January (MA)  
~~December~~ 8, 2018

RE: Good 2 Go: Broadway  
1401 Broadway Blvd. SE  
Grading and Drainage Plan  
Request for Temp C.O. - Accepted  
Engineer's Certification Dated 1/5/18  
Hydrology File: L14D022

DRAINAGE PLAN

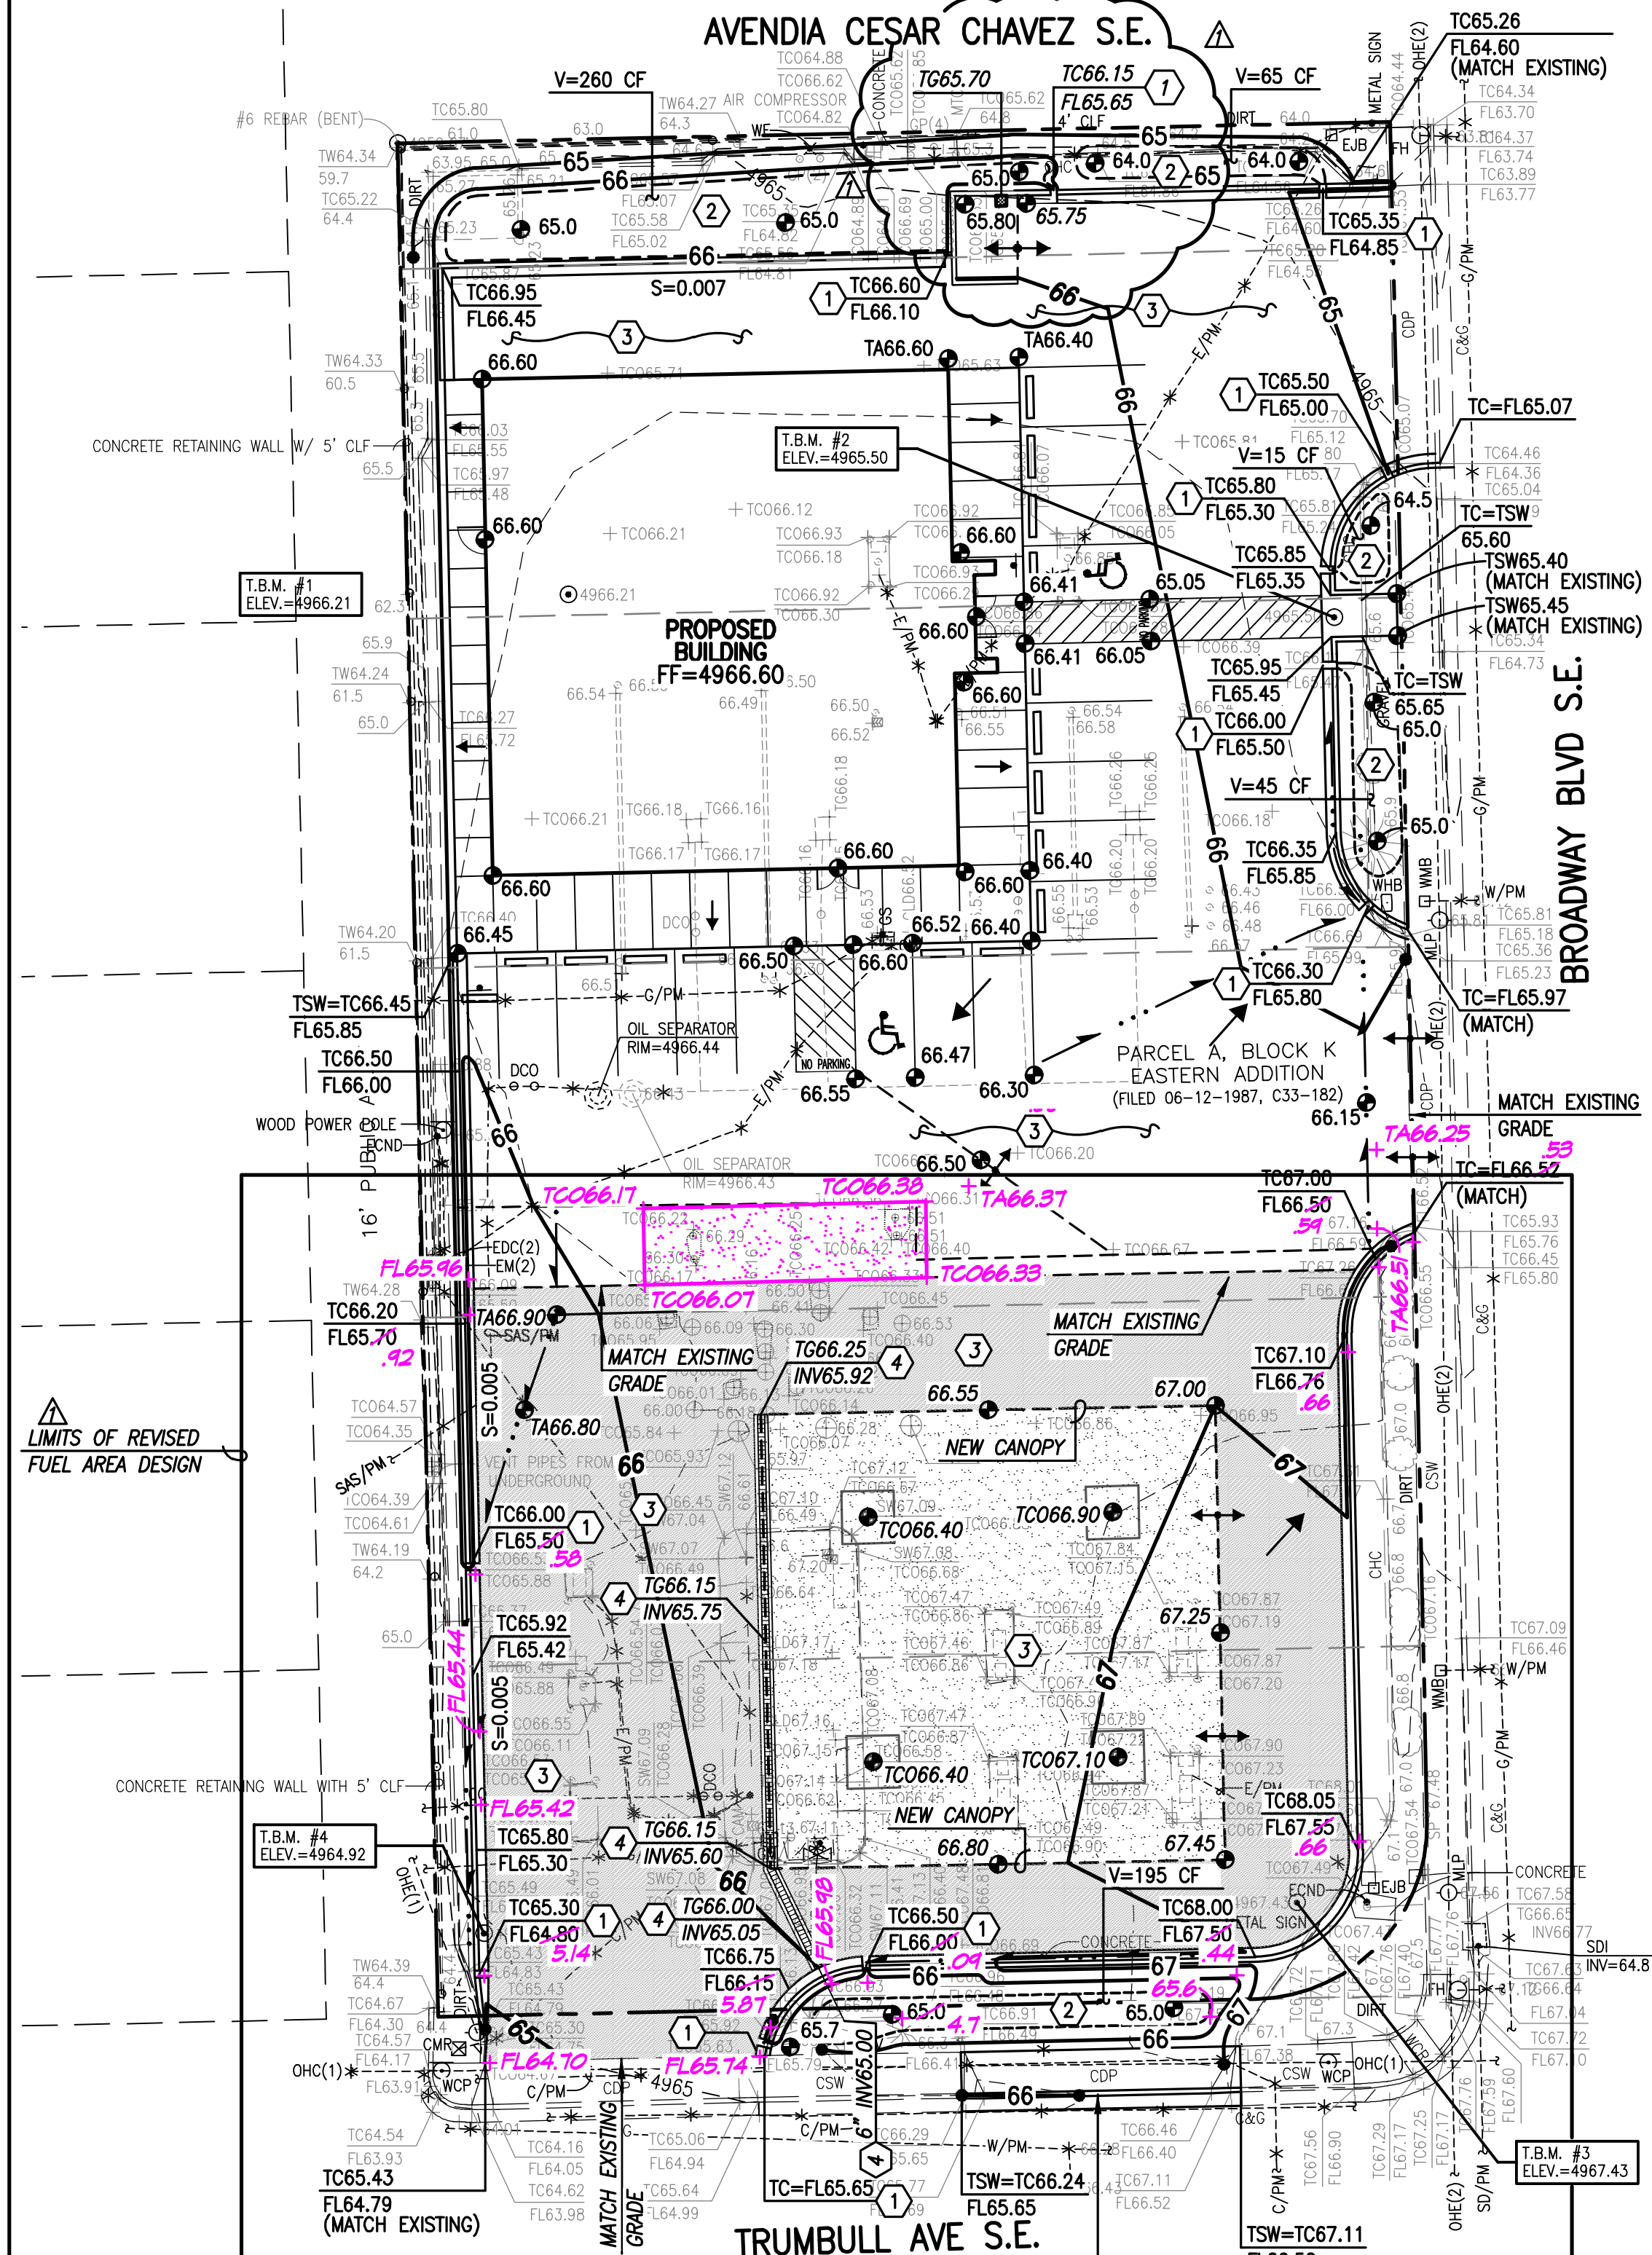
- The fueling area (roughly the south half of the site) must be completed prior to certification for permanent certification of occupancy.
- The north-south flowline west of the southernmost Broadway entrance lacks definition and may not adequately serve to direct runoff to the water quality basin. This area shall be flow tested in the presence of the engineer. If tested does not indicate compliance with the intent, then pavement correction will be required.
